CITY OF PORTLAND, MAINE
DEVELOPMENT REVIEW APPLICATION
PLANNING DEPARTMENT PROCESSING FORM

2004-0137

Boathouse/Guesthouse

328 - 328 Island Ave, Portland, Maine

BOUNDARY SURVEY PLAN
334 ISLAND AVE PEAKS ISLAND, MAINE

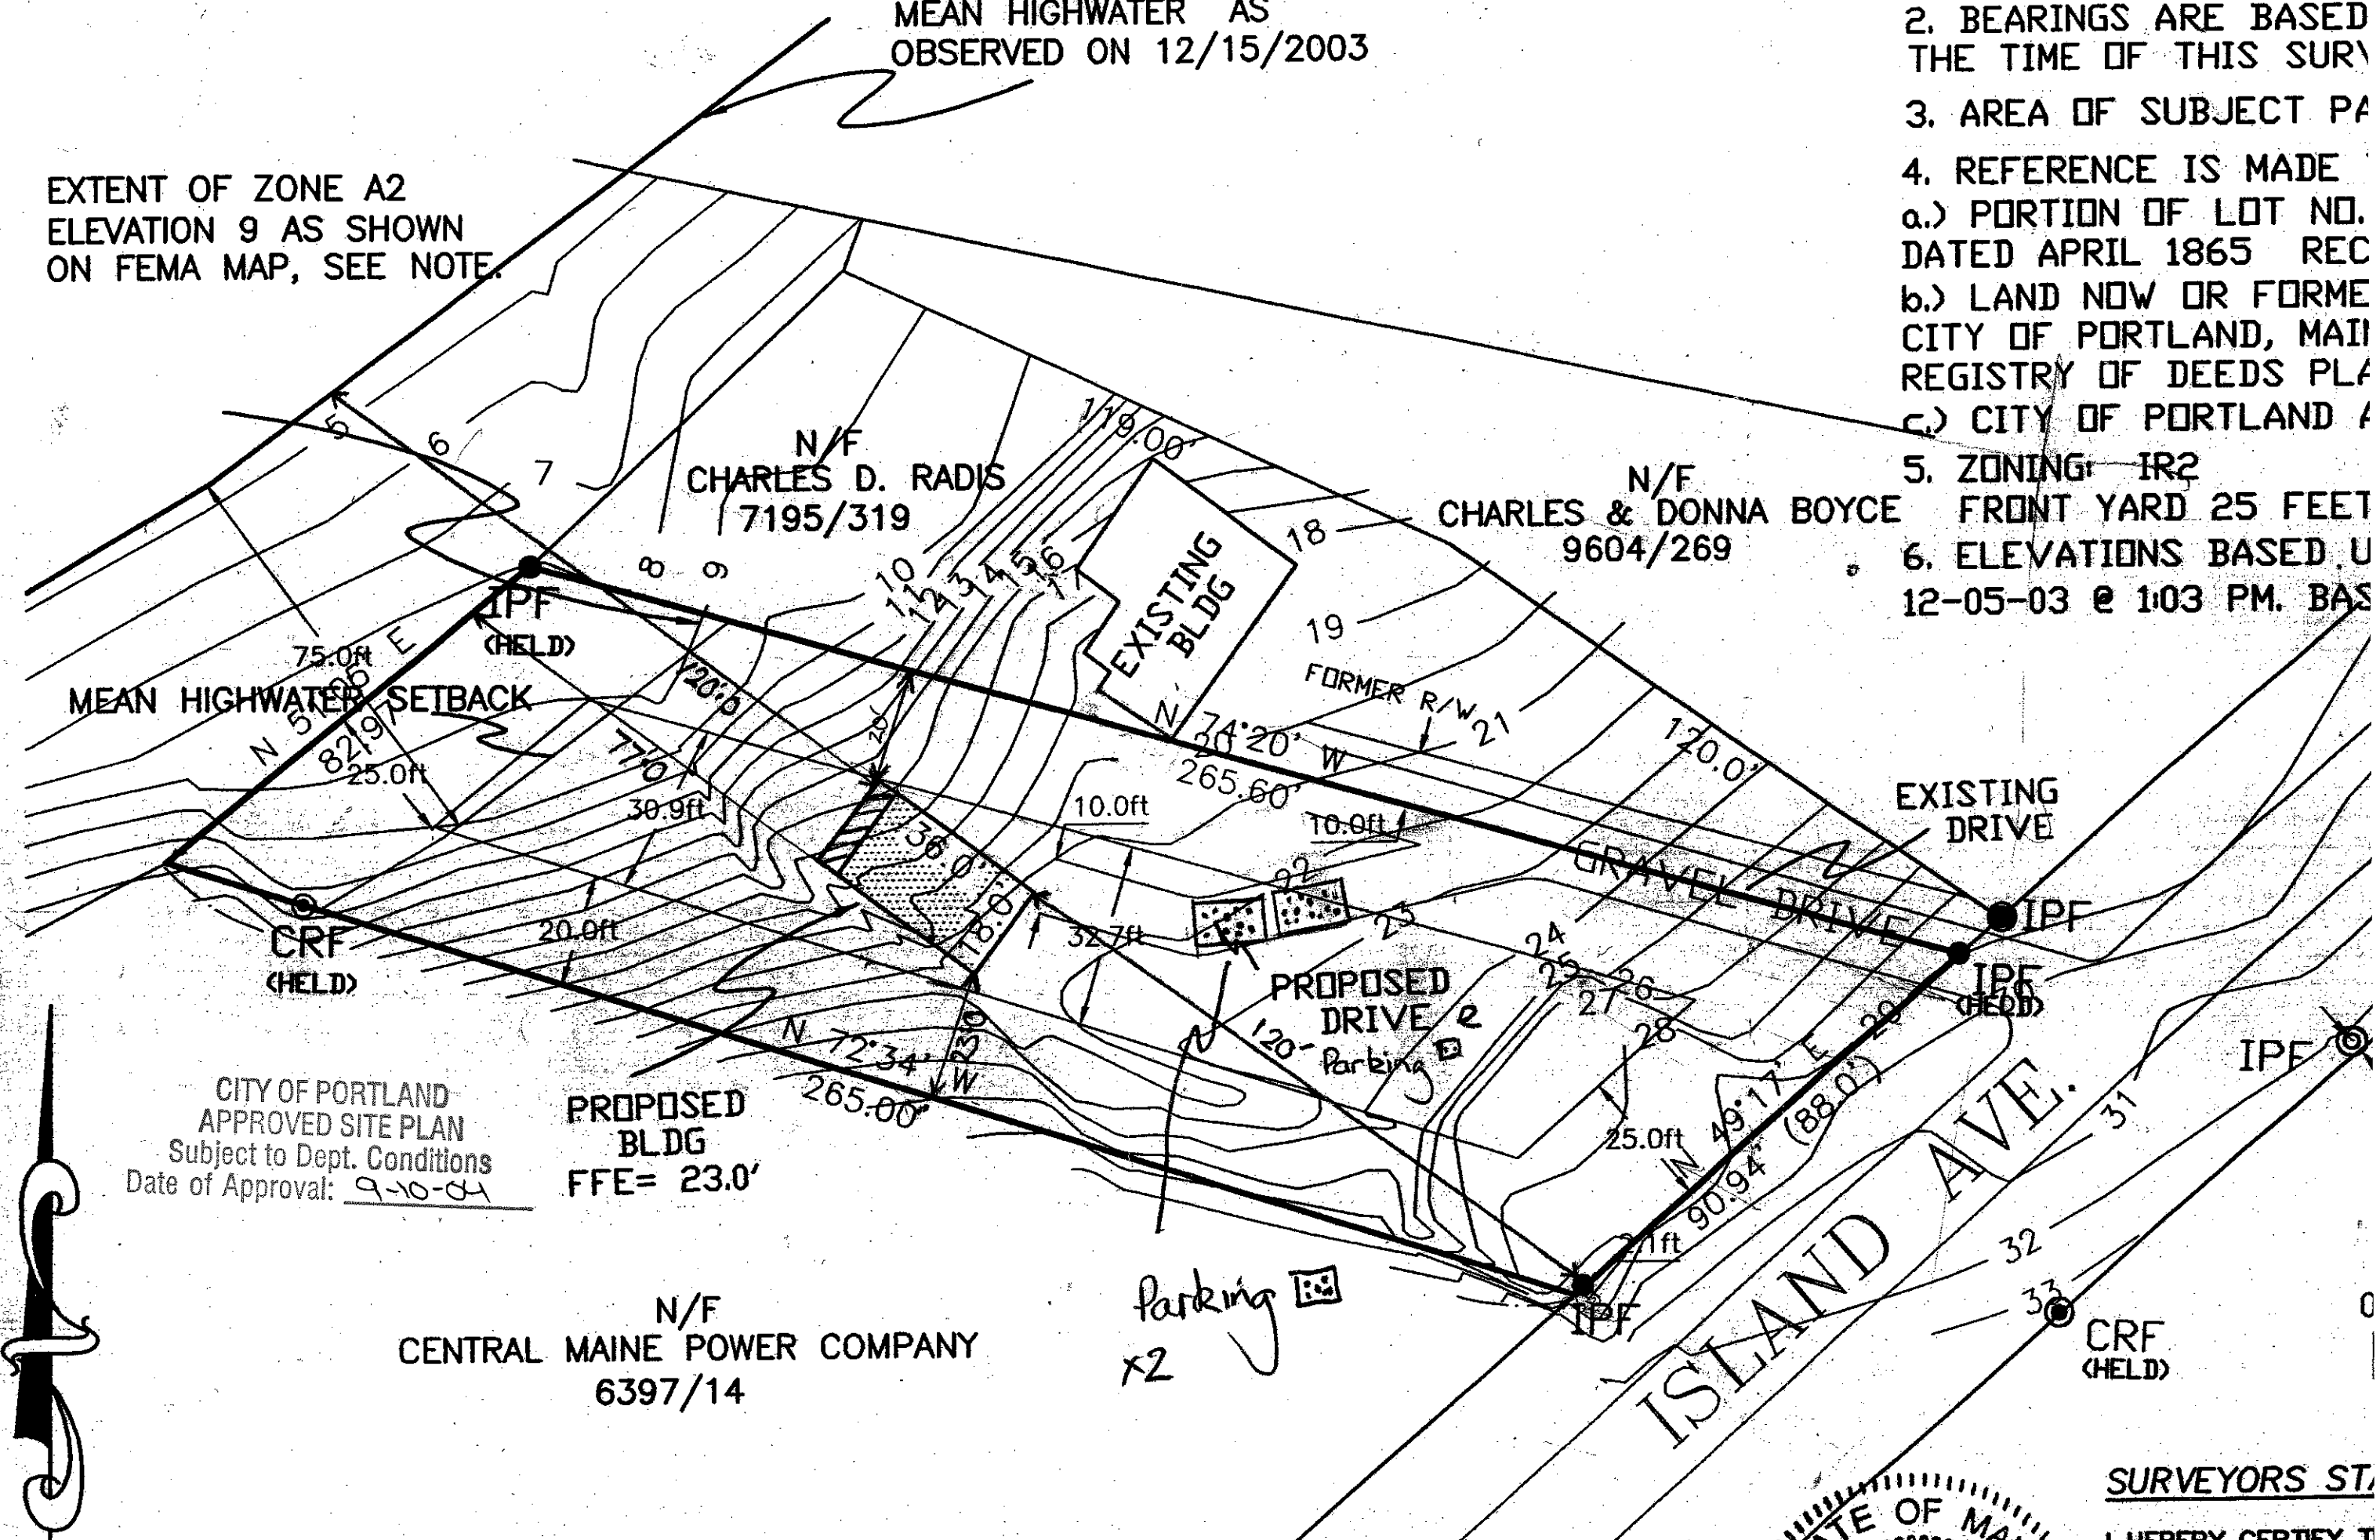
Prop. Live, setbacks, frontage, units - Marge
Prop. Top Show Septic
Any water, sewer, etc?
Silt fence?
Former R/W on brown R

- 1 All Site work (final grading, landscaping, loam and seed) must be completed prior to issuance of a certificate of occupancy.
- 2 Your new street address is now #328 Island Ave., the number must be displayed on the street frontage of your house prior to issuance of a Certificate of Occupancy.
- 3 Two (2) City of Portland approved species and size trees must be planted on your street frontage prior to issuance of a Certificate of Occupancy.
- 4 A sewer permit is required for you project. Please contact Carol Merritt at 874-8300, ext . 8822. The Wastewater and Drainage section of Public Works must be notified five (5) working days prior to sewer connection to schedule an inspector for your site.
- 5 NO CHANGES IN GRADING IS PROPOSED. ANY CHANGES IN TOPOGRAPHY SHALL REQUIRE ADDITIONAL REVIEW AND APPROVAL BY THE CITY.
